### RE: Coe Large Lot (LL-08-01)

The Kittitas County Community Development Services Department has determined that the Coe Large Lot (LL-08-01) is a complete application and hereby grants **conditional preliminary approval** subject to the following conditions:

TO: Trudie Pettit, Community Development Services  
FROM: Christina Wollman, Planner II *CW*  
DATE: April 8, 2008  
SUBJECT: Coe Large Lot Subdivision LL-08-01

DWN BY <b>D. PIERCE</b>	DATE <b>02/2008</b>	JOB NO. <b>07099</b>
CHKD BY <b>D. NELSON</b>	SCALE <b>1"=400'</b>	SHEET <b>1 OF 2</b>

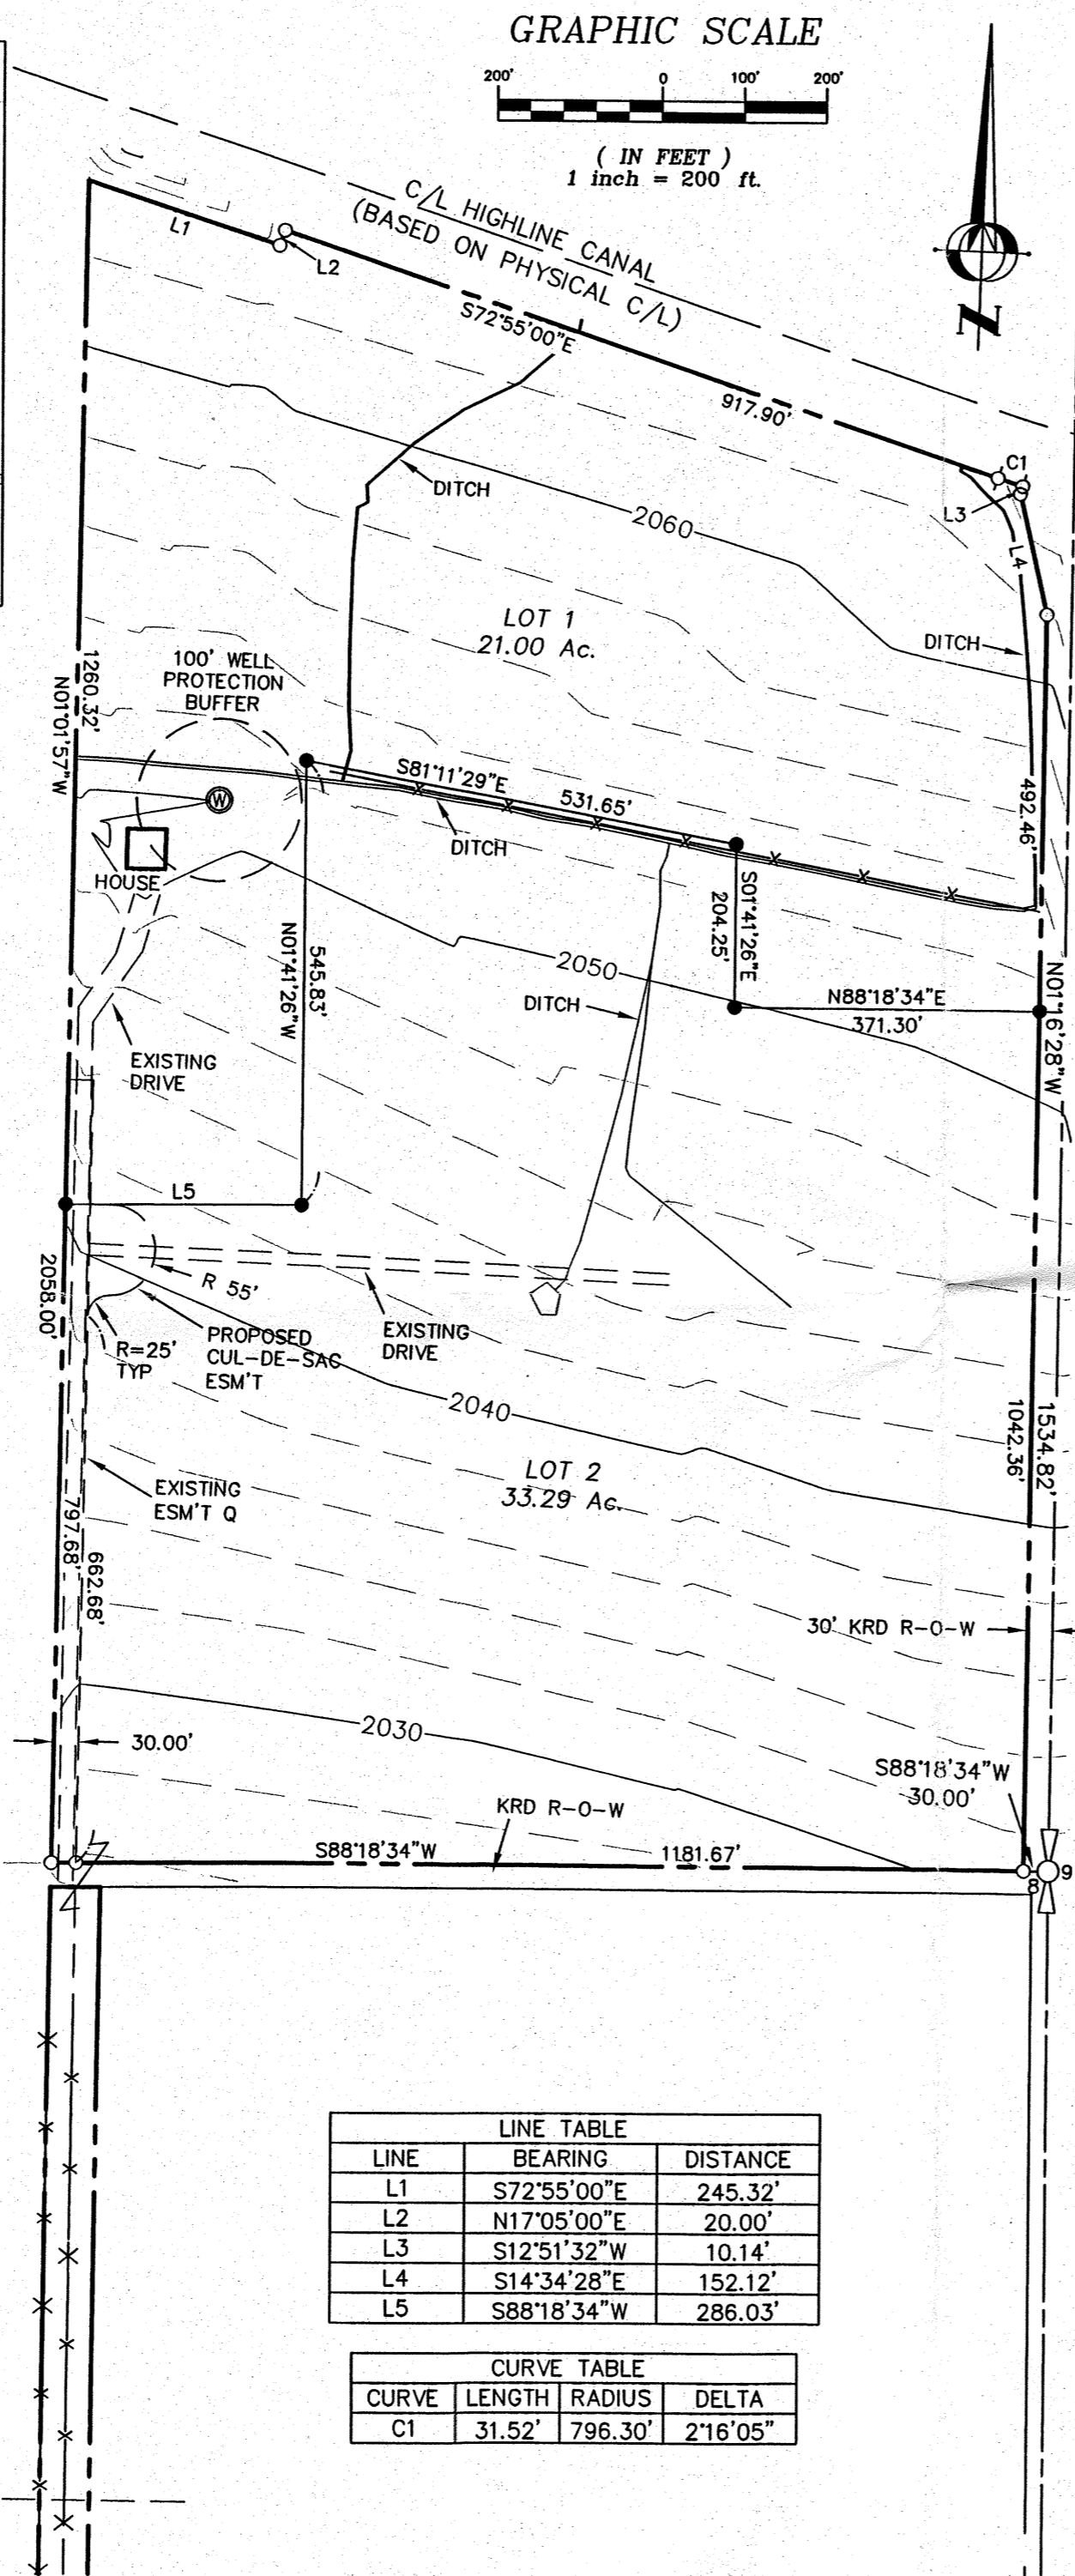
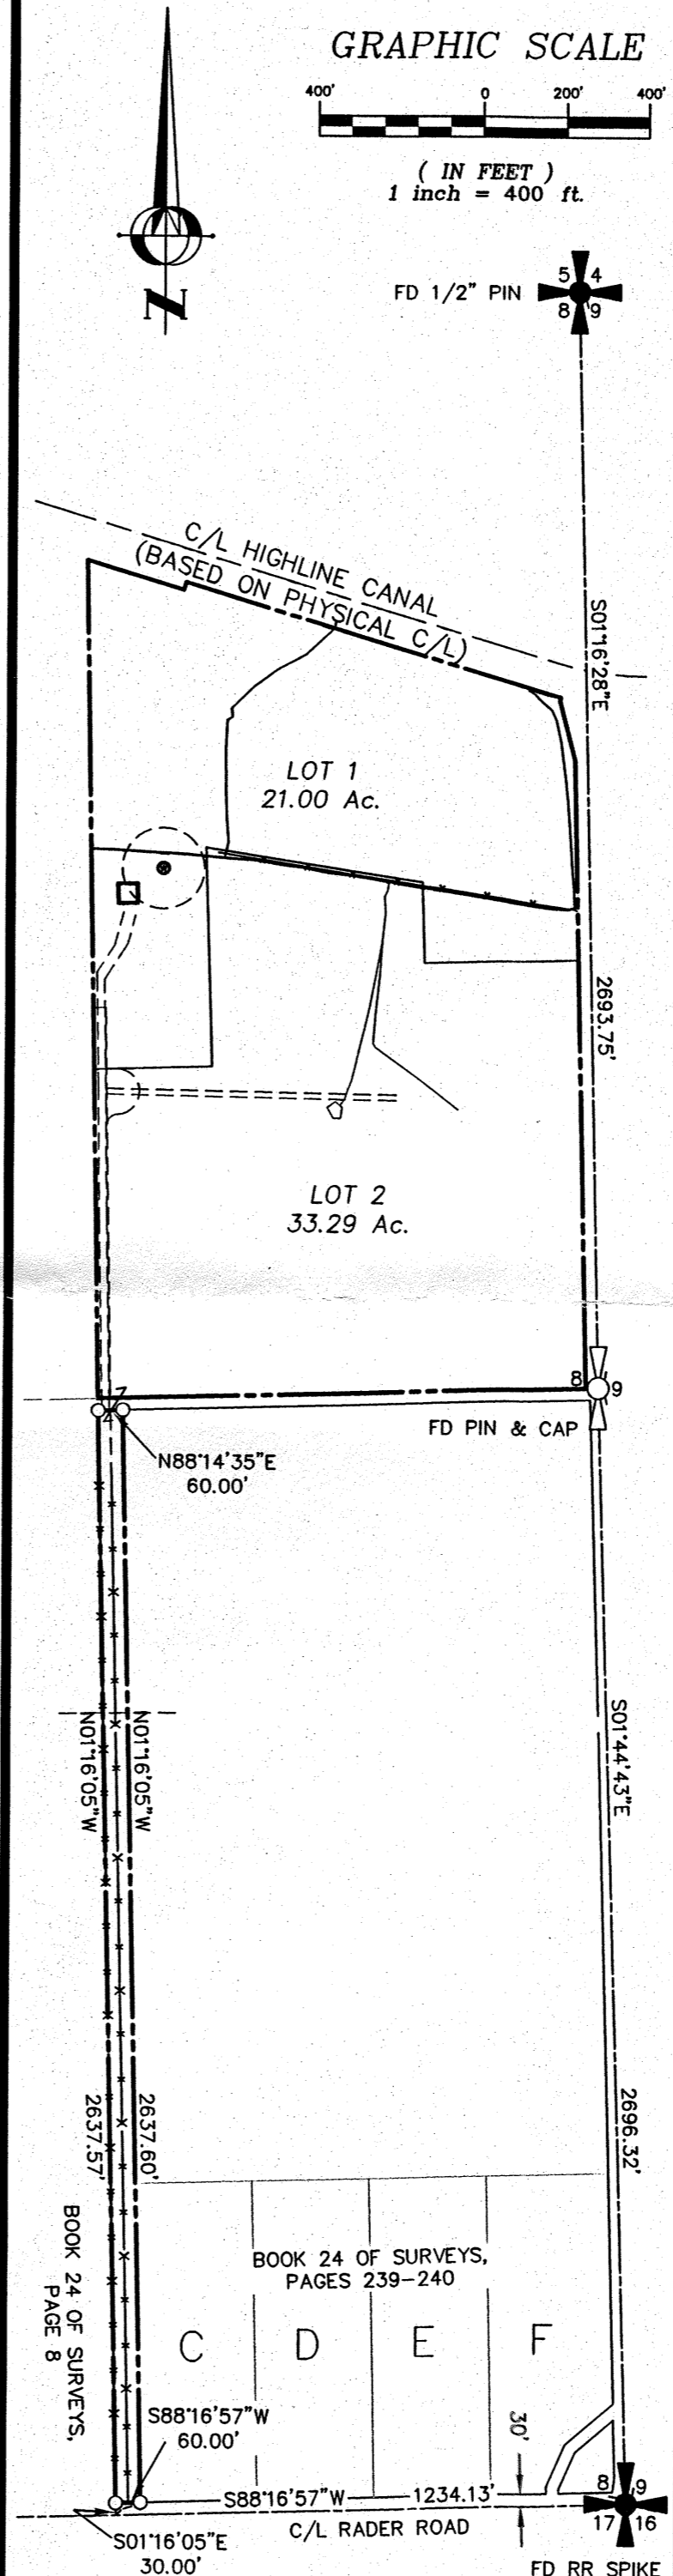
2. Adjacent Parcel Lines: The most recent survey for the parcels to the south is Book 34 Pages 42-43. The face of the survey shall be updated to reflect the correct adjacent parcel lines.

3. Access Easement: A 60' access easement is required from Rader Road to the cul-de-sac. A 55' radius cul-de-sac easement is required. The easement and any associated AFNs shall be shown on the face of the plat.
